re: Geotechnical Response to Peer Review Comments
Proposed High-Rise Building
1040 Somerset Street West - Ottawa

date: October 4, 2021

file: PG2674-MEMO.10

Geotechnical Investigation Report - Comments 1 to 4

Figure 8 - Section A - Construction Loading - Static Analysis

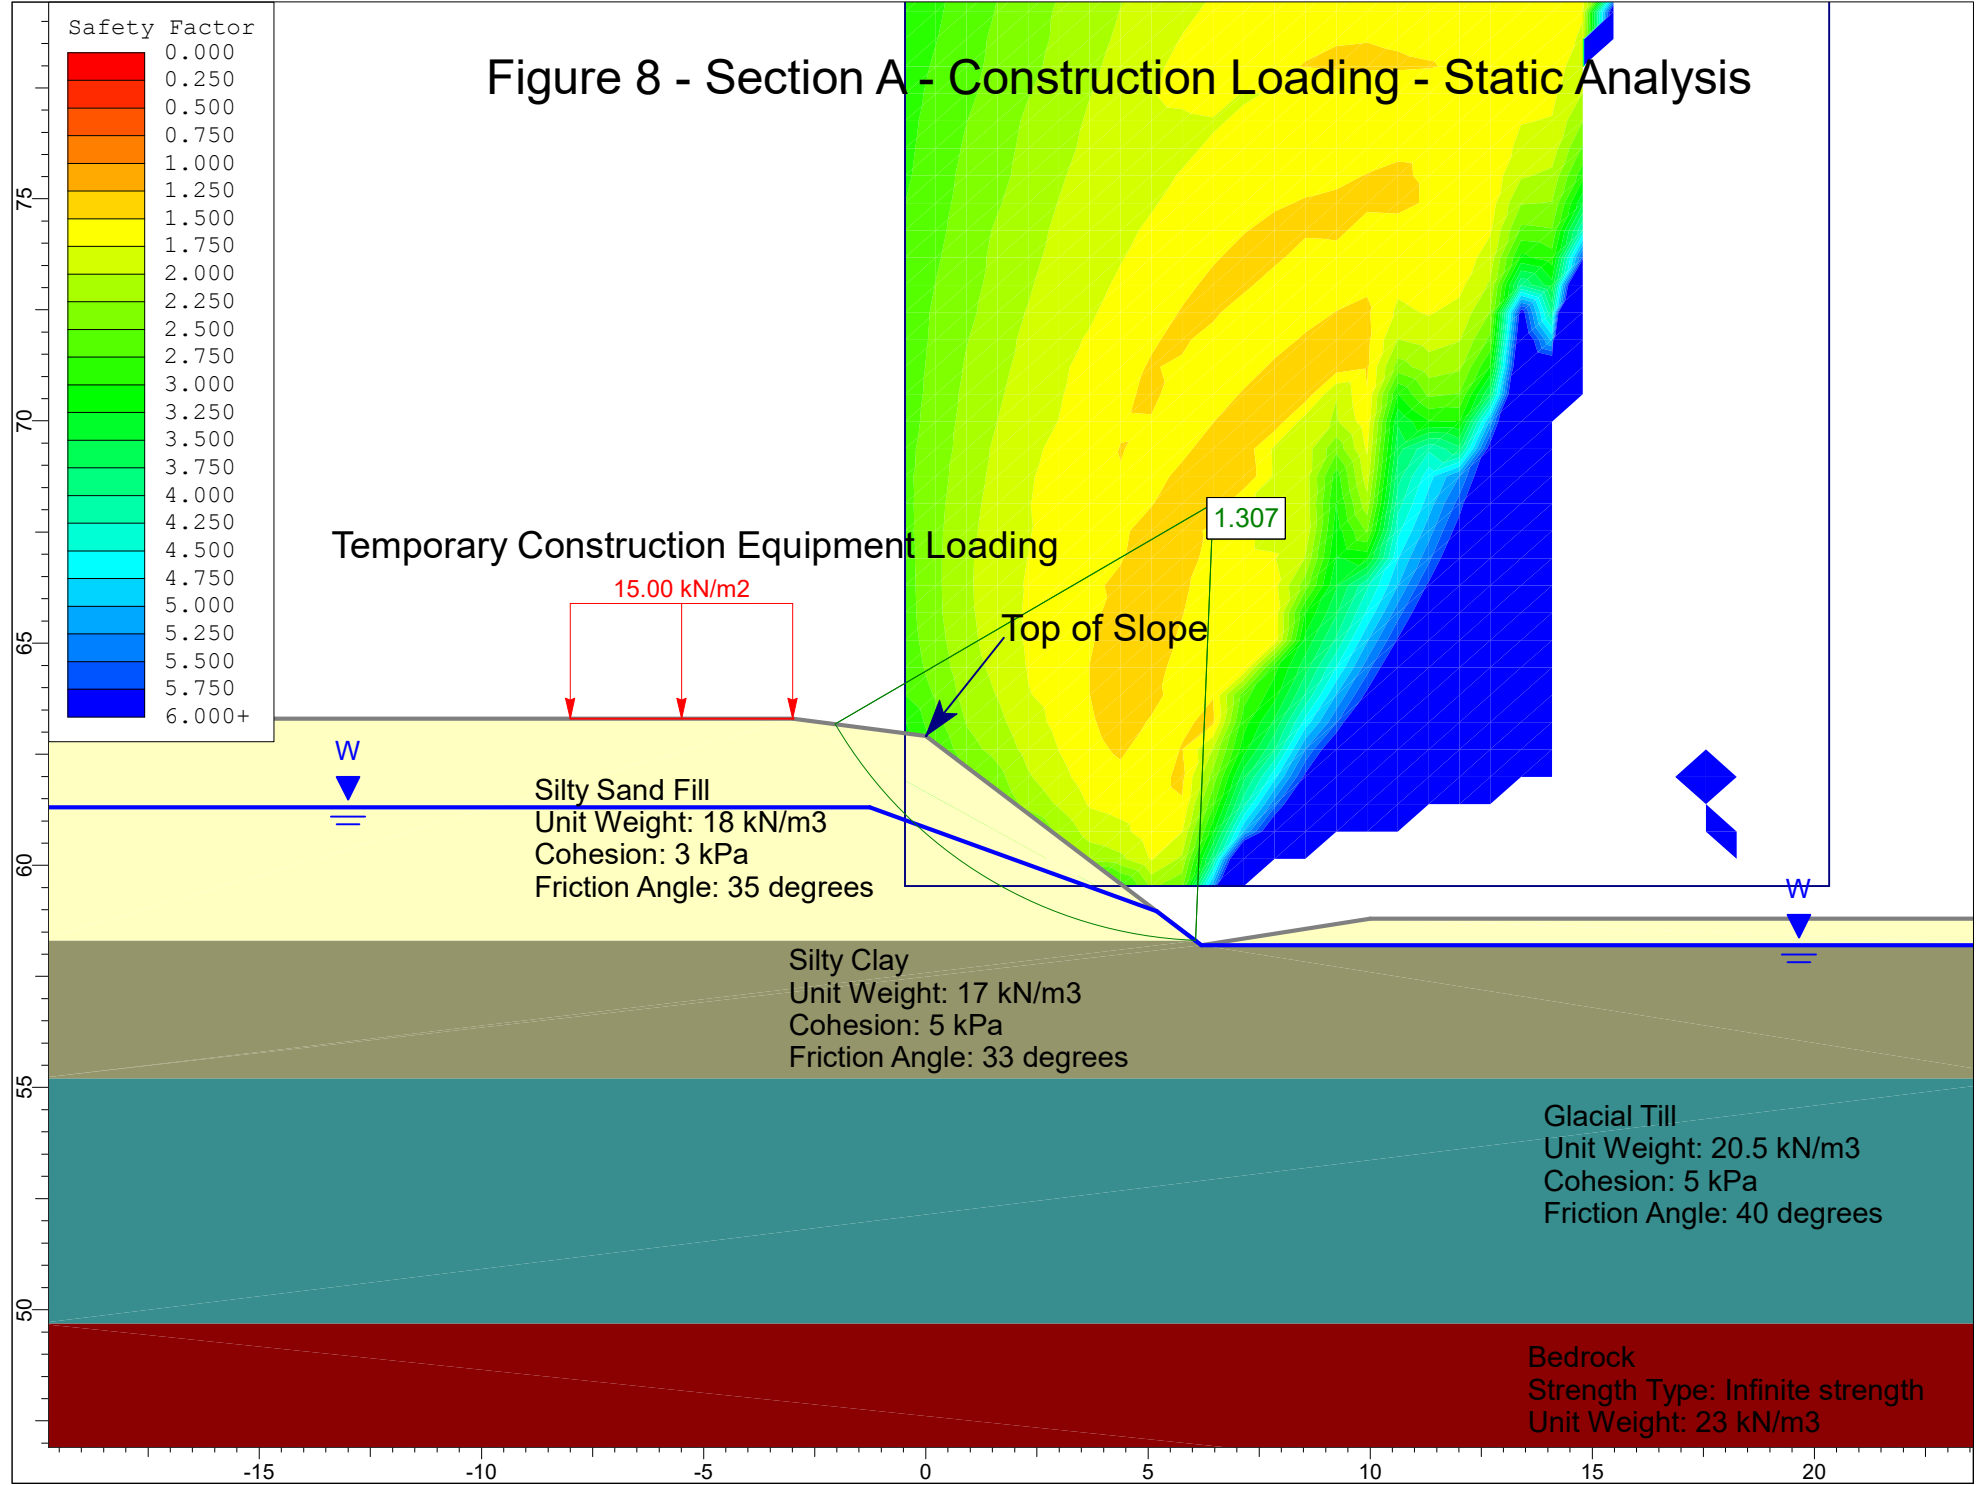
Comment 5: *The report includes slope stability evaluations under both static and seismic conditions for the west slope of the O-Train corridor indicating only a marginal safety factor against potential instability under the static condition. More detailed evaluation of the impact of the proposed construction methodology such as proposed dewatering, installation of sheet piles and tie backs, and equipment travel or operation on the stability of the existing and proposed slopes is therefore recommended.*

DST Comment August 26, 2021: *DST recommends that an evaluation of the slope stability be performed for several possible scenarios anticipated during the proposed construction near the West slope of the O-Train corridor. At a minimum the slope stability analyses should include the impacts of the construction equipment during the proposed pile driving operations.*

Response: Please refer to Figure 8 in Appendix 2 of the updated Geotechnical Investigation Report (Paterson Group Report PG2674-2 Revision 4 dated October 4, 2021), which provides the slope stability analysis for temporary equipment surcharge loading on the slope during construction. As noted in the report, the factor of safety of 1.3 under static conditions for this scenario represents a stable slope condition under temporary equipment surcharge loading. As the equipment surcharge loading is a very temporary condition, analyzing this scenario under seismic conditions is not considered to be required.
